From: Ian Stocks [REDACTED] **On Behalf Of** FRS Water and Access
Sent: 23 December 2021 07:58
To: Planning.Responses <Planning.Responses@arun.gov.uk>
Subject: RE: Planning Consultation on: P/171/21/DOC

Application No: P/171/21/DOC

Site Address: Rear of Inglenook Hotel 253-255 Pagham Road Pagham PO21 3QB

Description of Works: Approval of details reserved by condition imposed under ref W/4001476 (P/58/19/PL) relating to Condition Nos 10 - proposed location of one fire hydrant or stored water supply, 12 - soft & hard landscaping, 14 - materials & finishes and 15 - boundary treatments.

INGLENOOK PROPOSED FIRE MAIN SKETCH

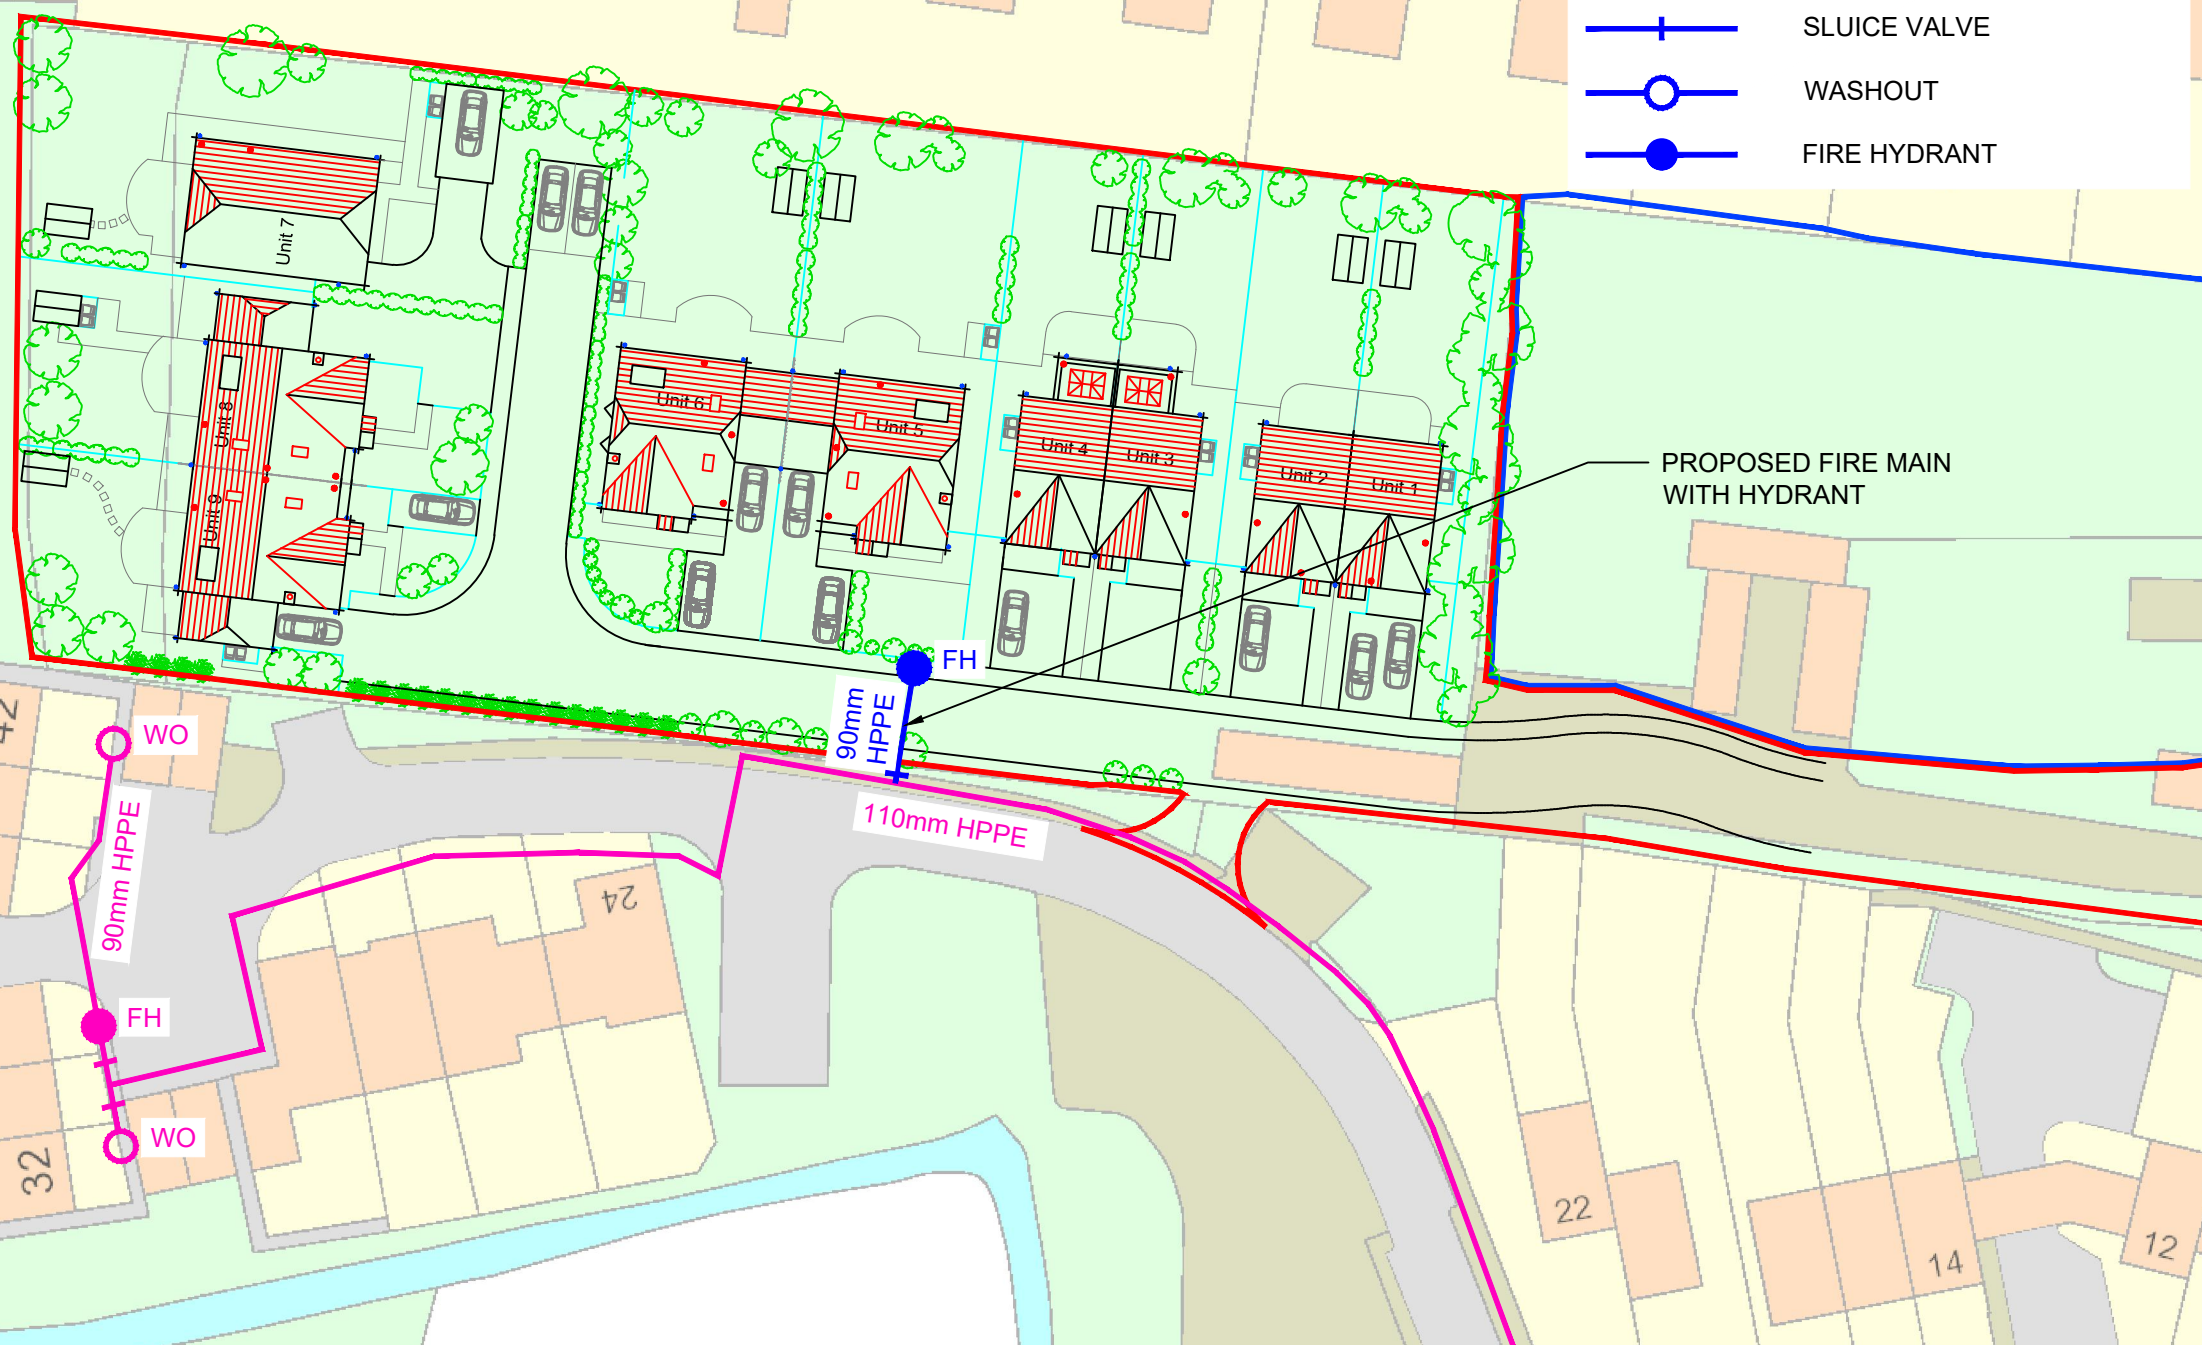
West Sussex Fire and Rescue Service agree in principal with the provision of a fire hydrant in the position indicated on the fire main sketch drawing. However until the fire hydrant is in place and available for use by the Fire Service we would not consider the condition to have been met. The Fire Service are rarely informed when a fire hydrant is in place and ready for use, often the site is occupied before we are informed.

Without the fire hydrant being tested, location identified with an H plate, cover sprayed yellow and plotted in our mapping system, any attending Fire Crews would not be aware of any fire hydrants on site when attending a fire which could potentially put properties and lives at risk.
